Ref. M/62/19/PL

Planning Application for a 2-story
dwelling in Sundale Lane.

Drawing Title
Block Plan and Site Plan

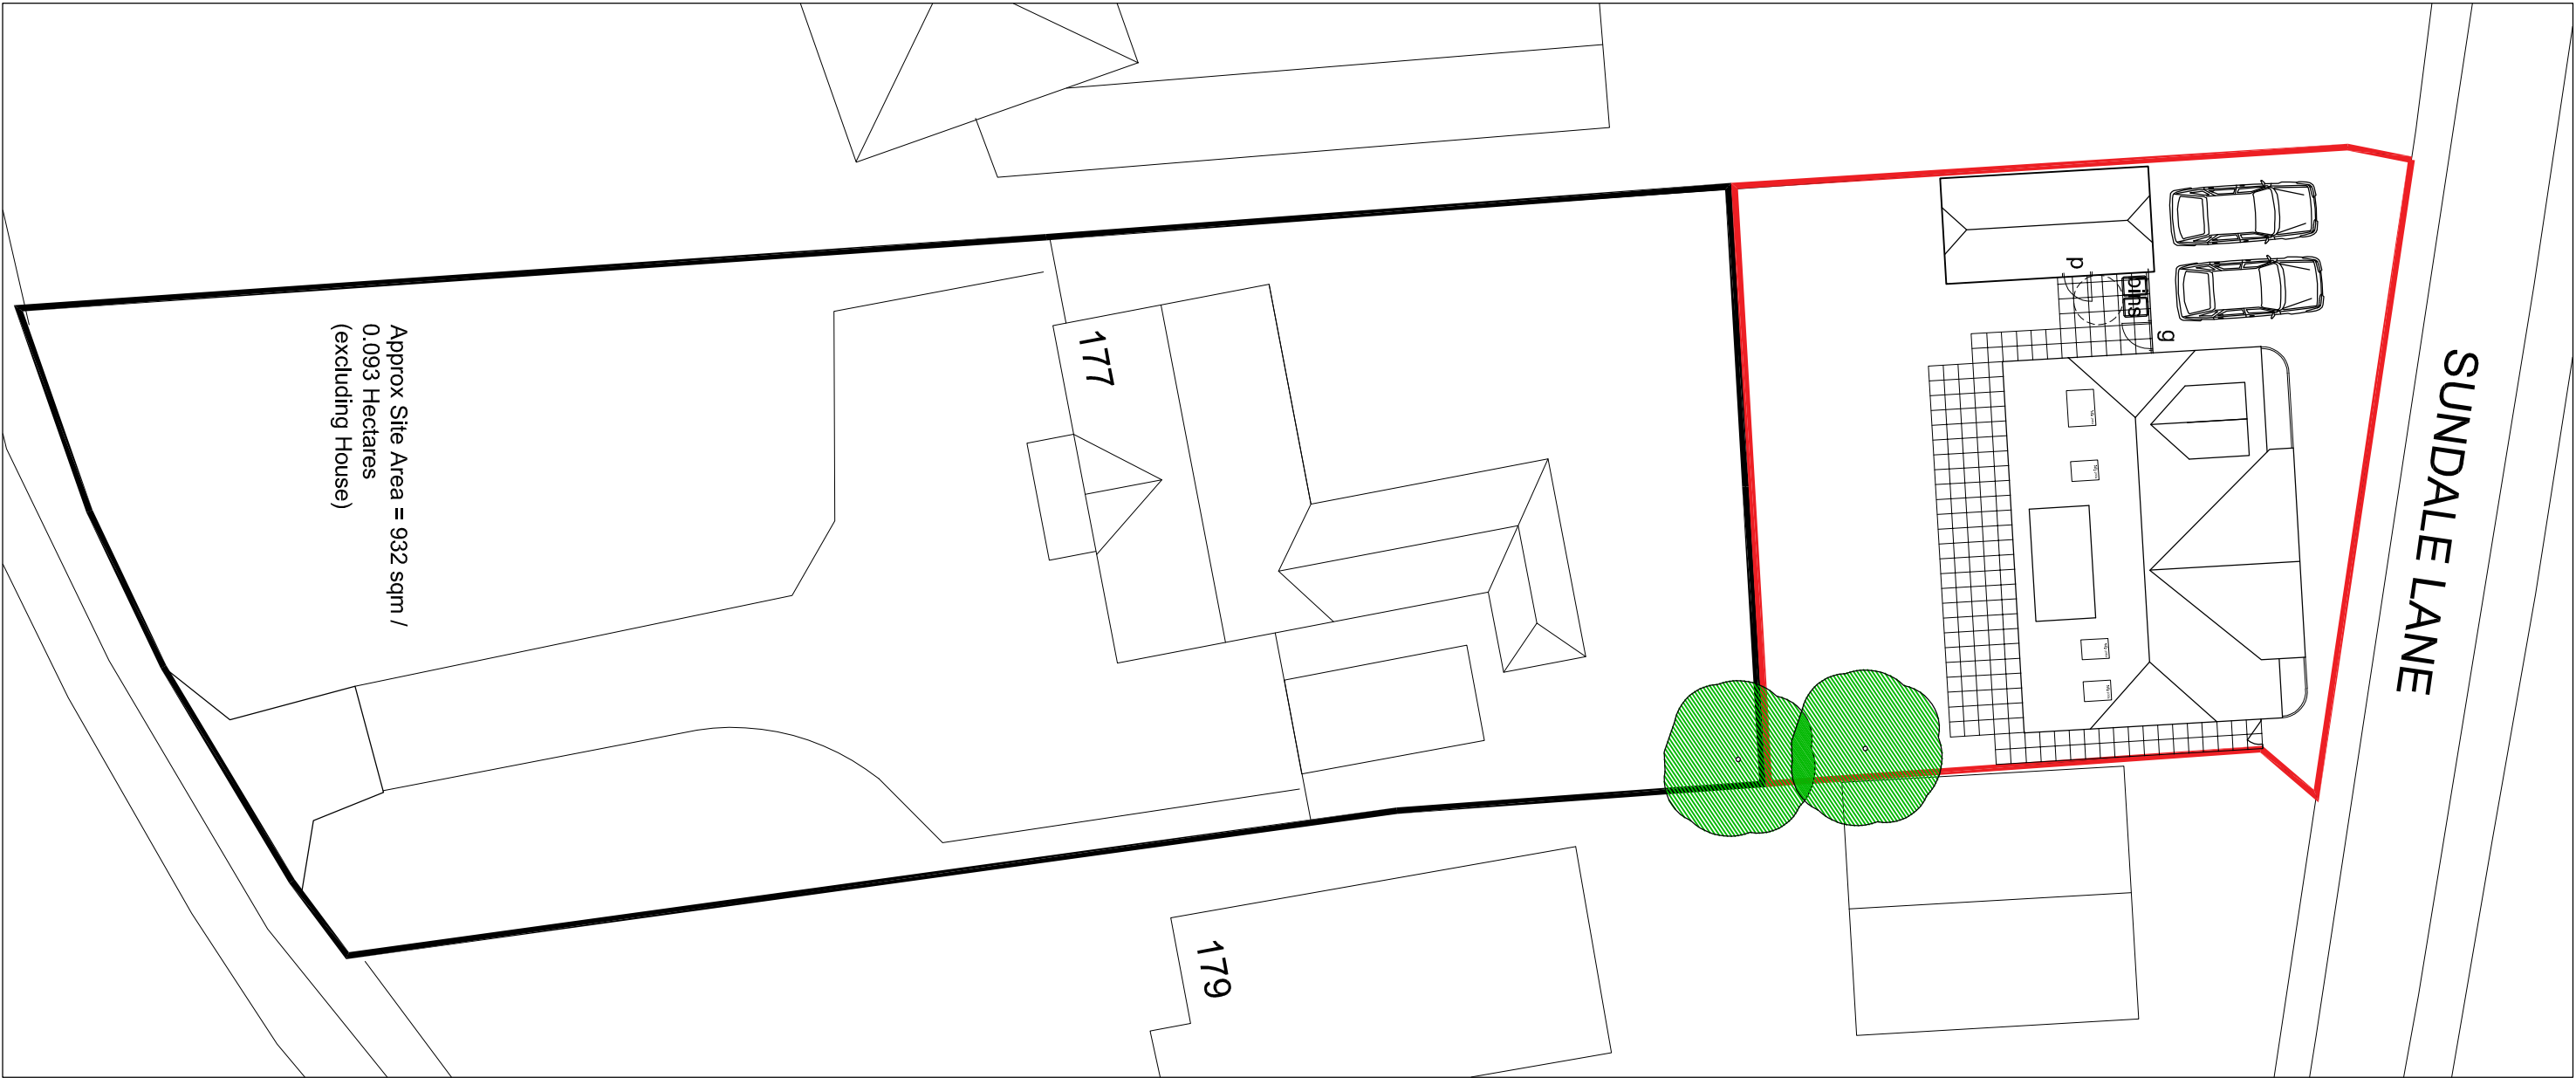
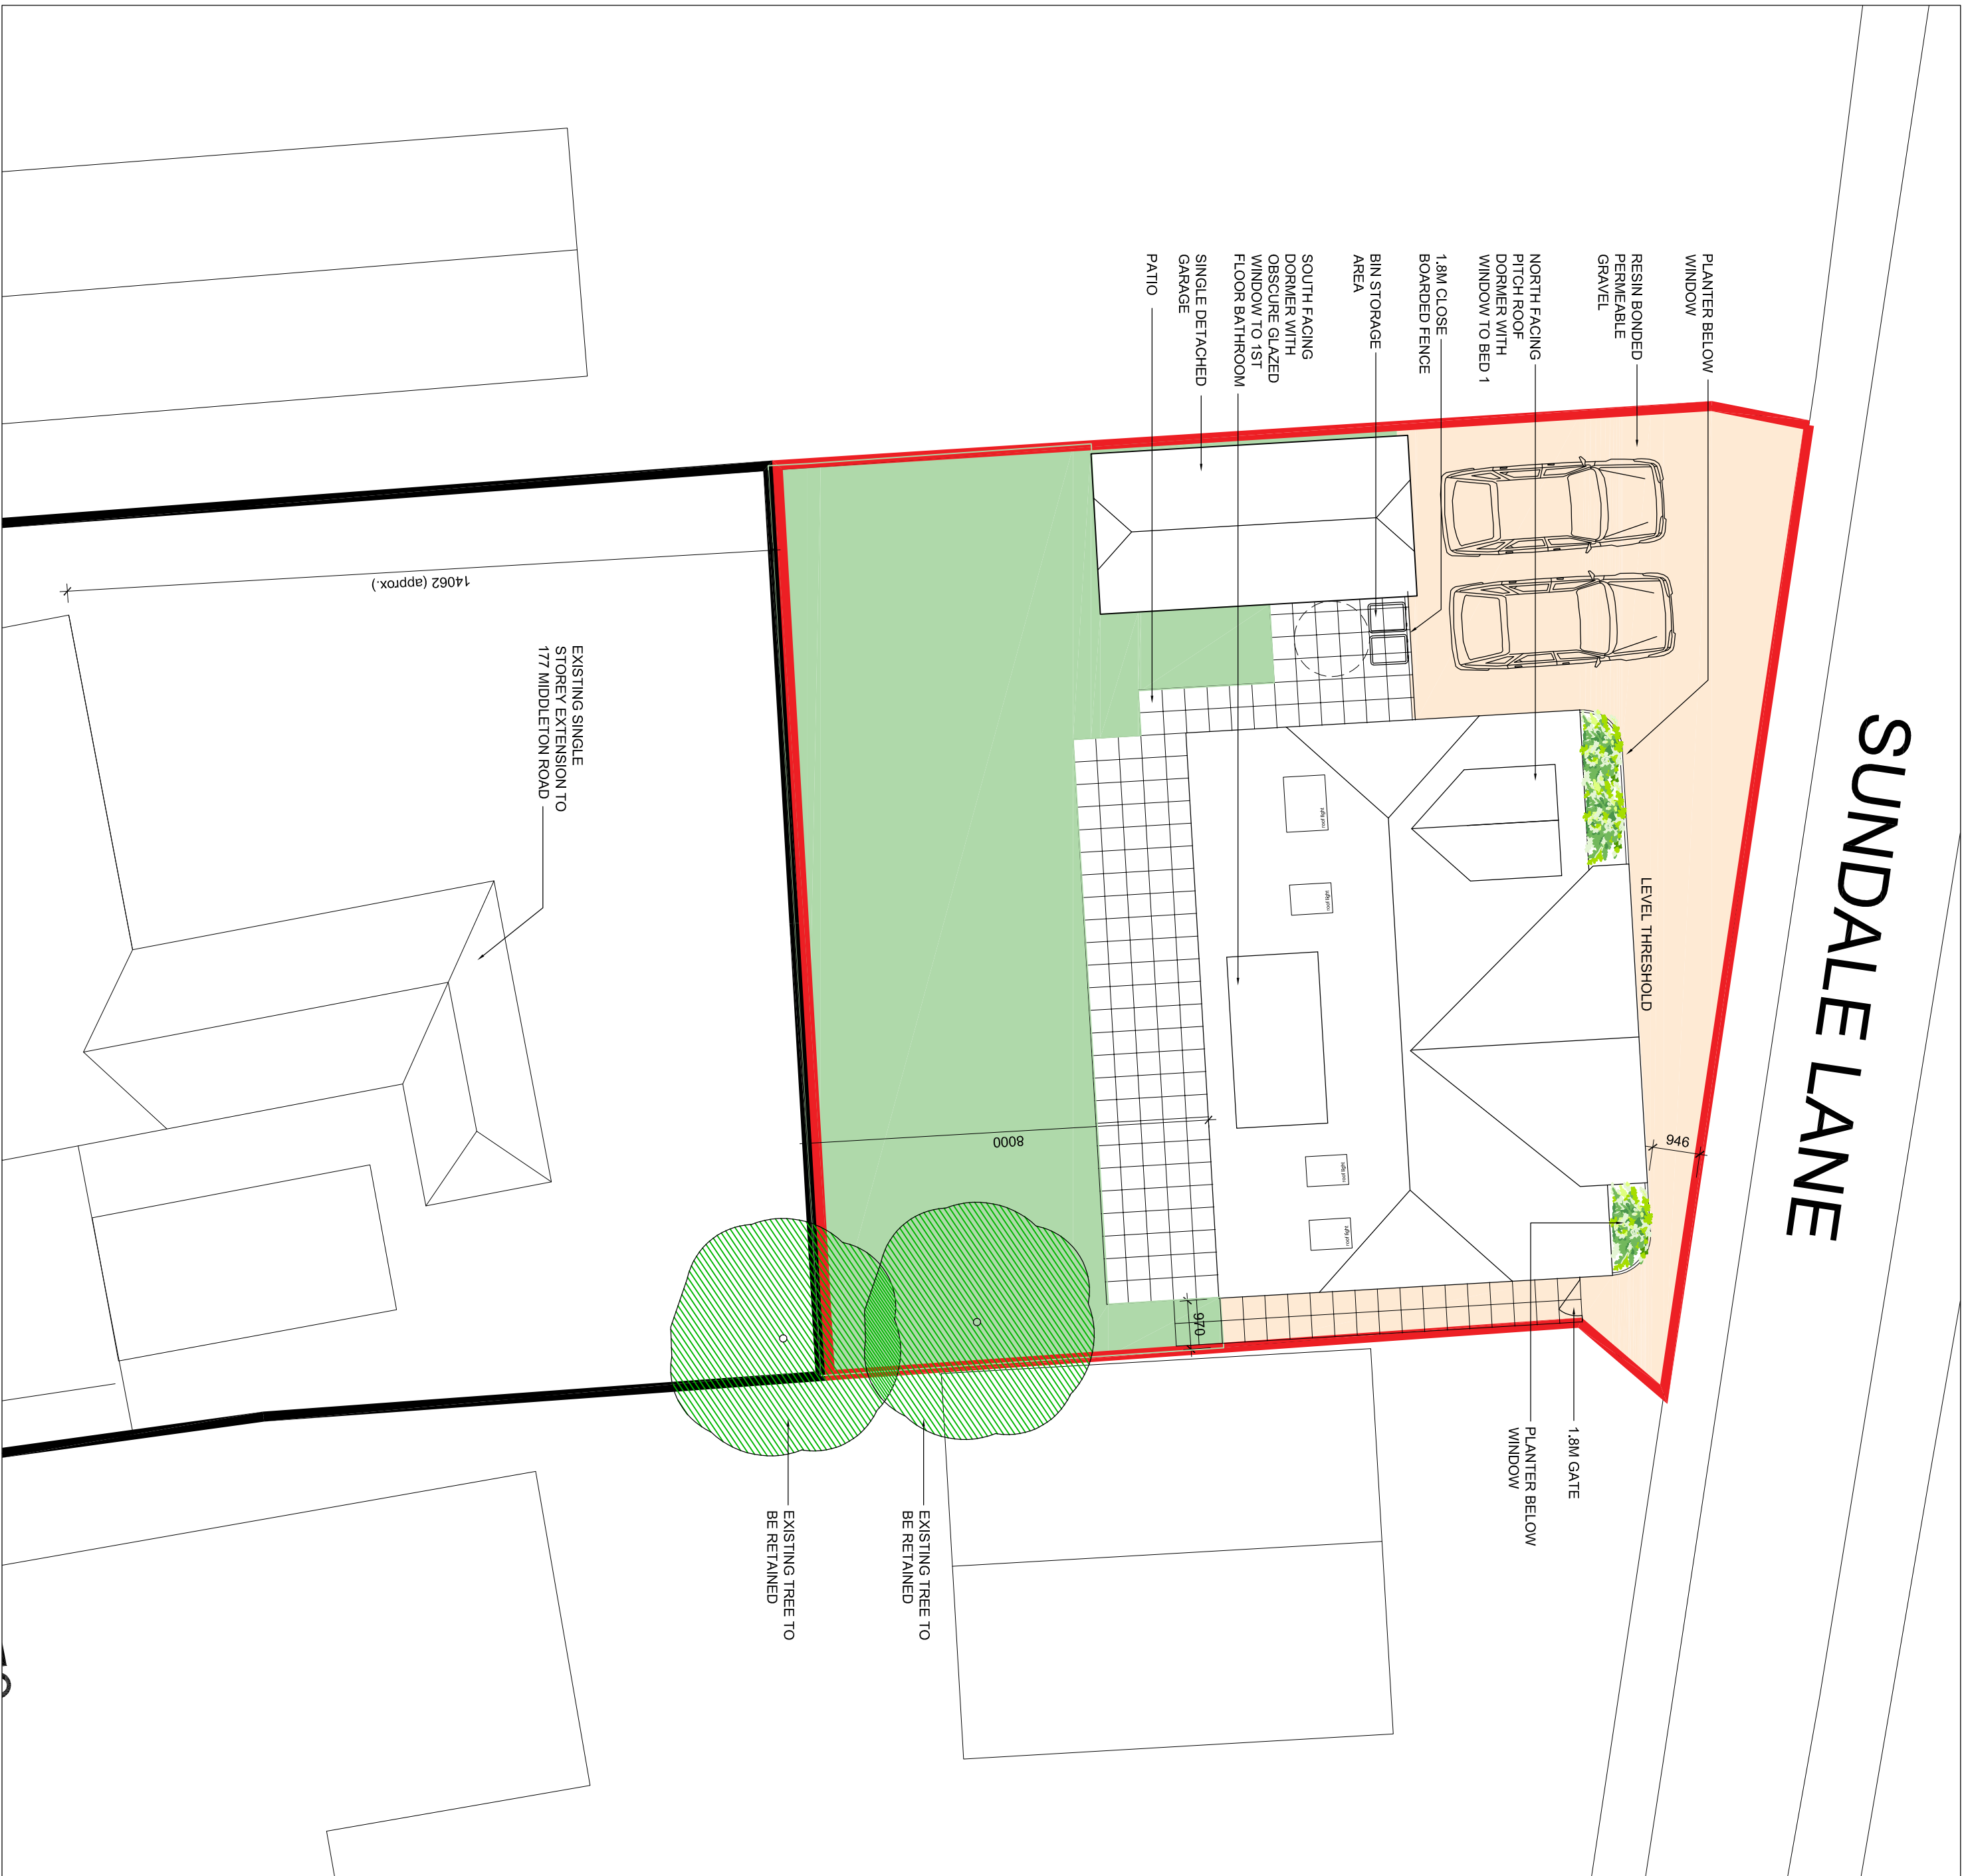
- ③ I cannot see how the existing oak tree could be protected if the house is built in the position shown on the plans.
